## Thomas FitzGerald - Online Submission from Jannece Thebridge (object)

Submission for Job: #3509  
[https://majorprojects.affinitylive.com/?action=view\\_job&id=3509](https://majorprojects.affinitylive.com/?action=view_job&id=3509)

Site: #2109 Residential subdivision at Fraser Drive, Terranora  
[https://majorprojects.affinitylive.com/?action=view\\_site&id=2109](https://majorprojects.affinitylive.com/?action=view_site&id=2109)

REF. No.	DATE	DRAWING No./Size	Sheet	Of	Rev.
T15263	11-3-2010	18053 B	2	8	H

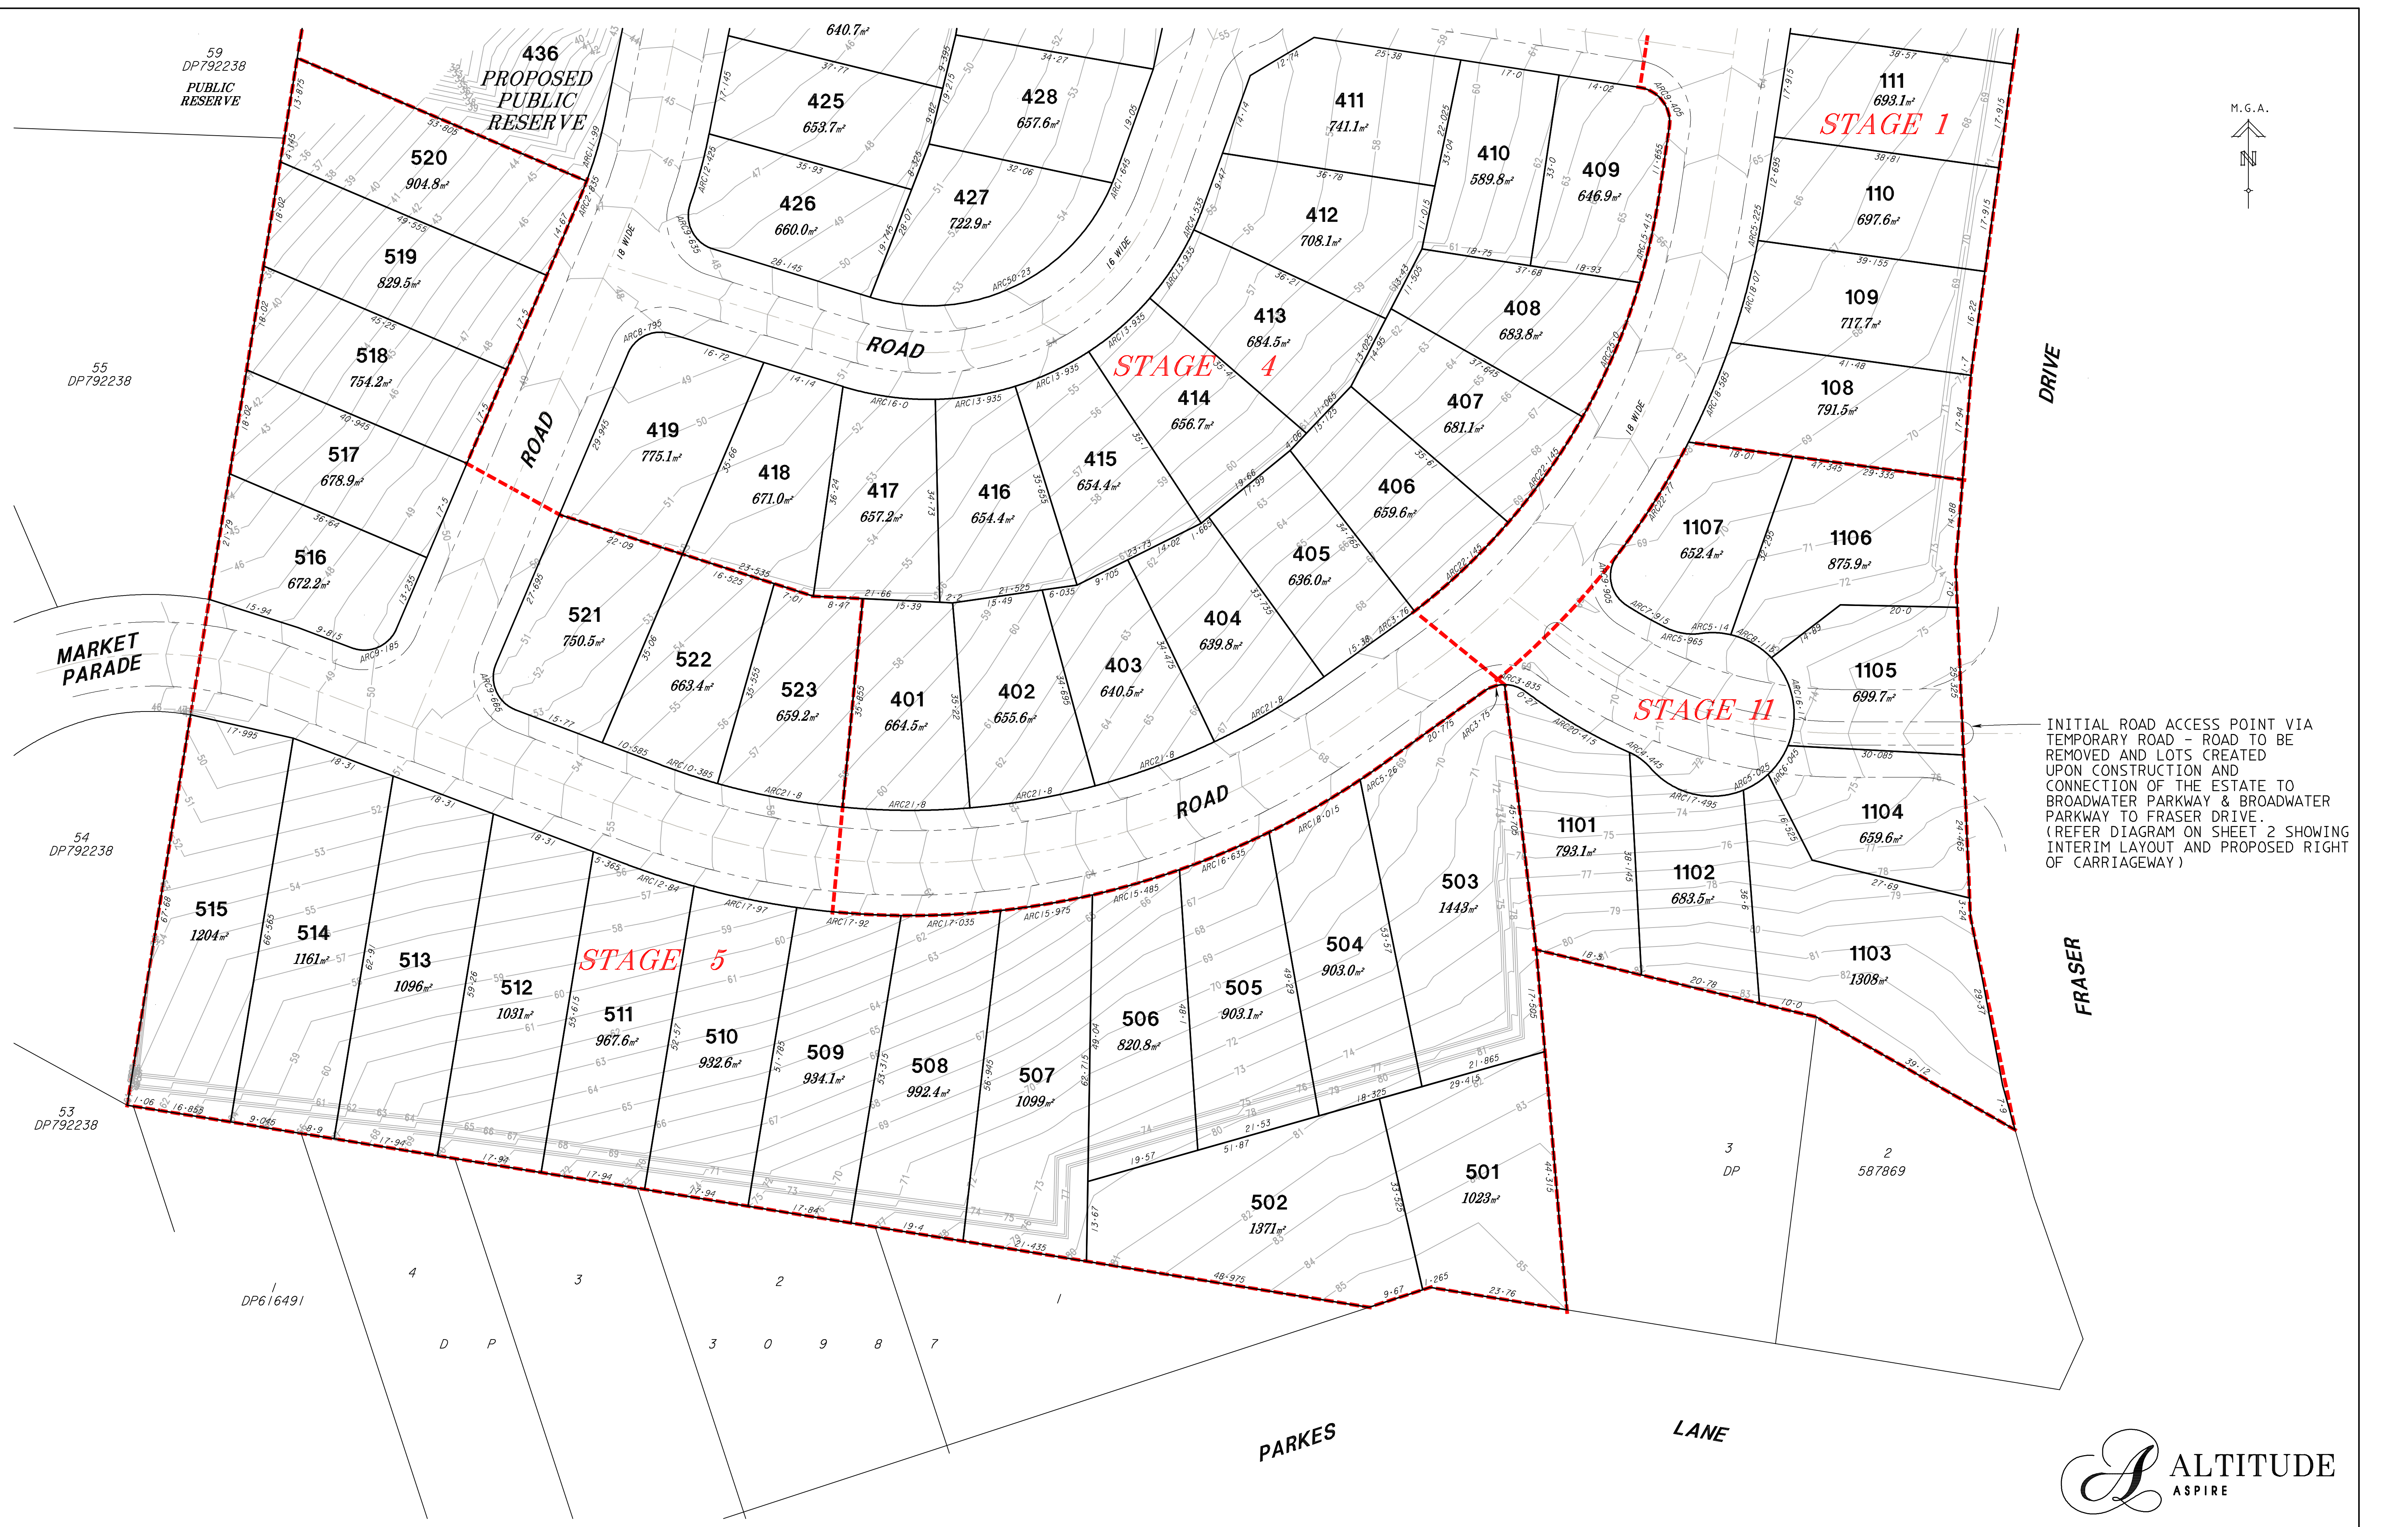
a. Many blocks are under 500 sq m. This will result in a community of approximately 4 or 5 houses crammed into the average sized block of the adjacent community. This housing density is overly excessive and needs to be slashed to be in harmony with its surrounds.

b. To enable this high density, the current landscape will require trashing to cut and fill. Once again, this is in stark contrast to the neighbourhood.

c. The house designs are planned to utilise every bit of space in a current community where space is in abundance. This cannot foster harmonious relations between the two communities which will develop.
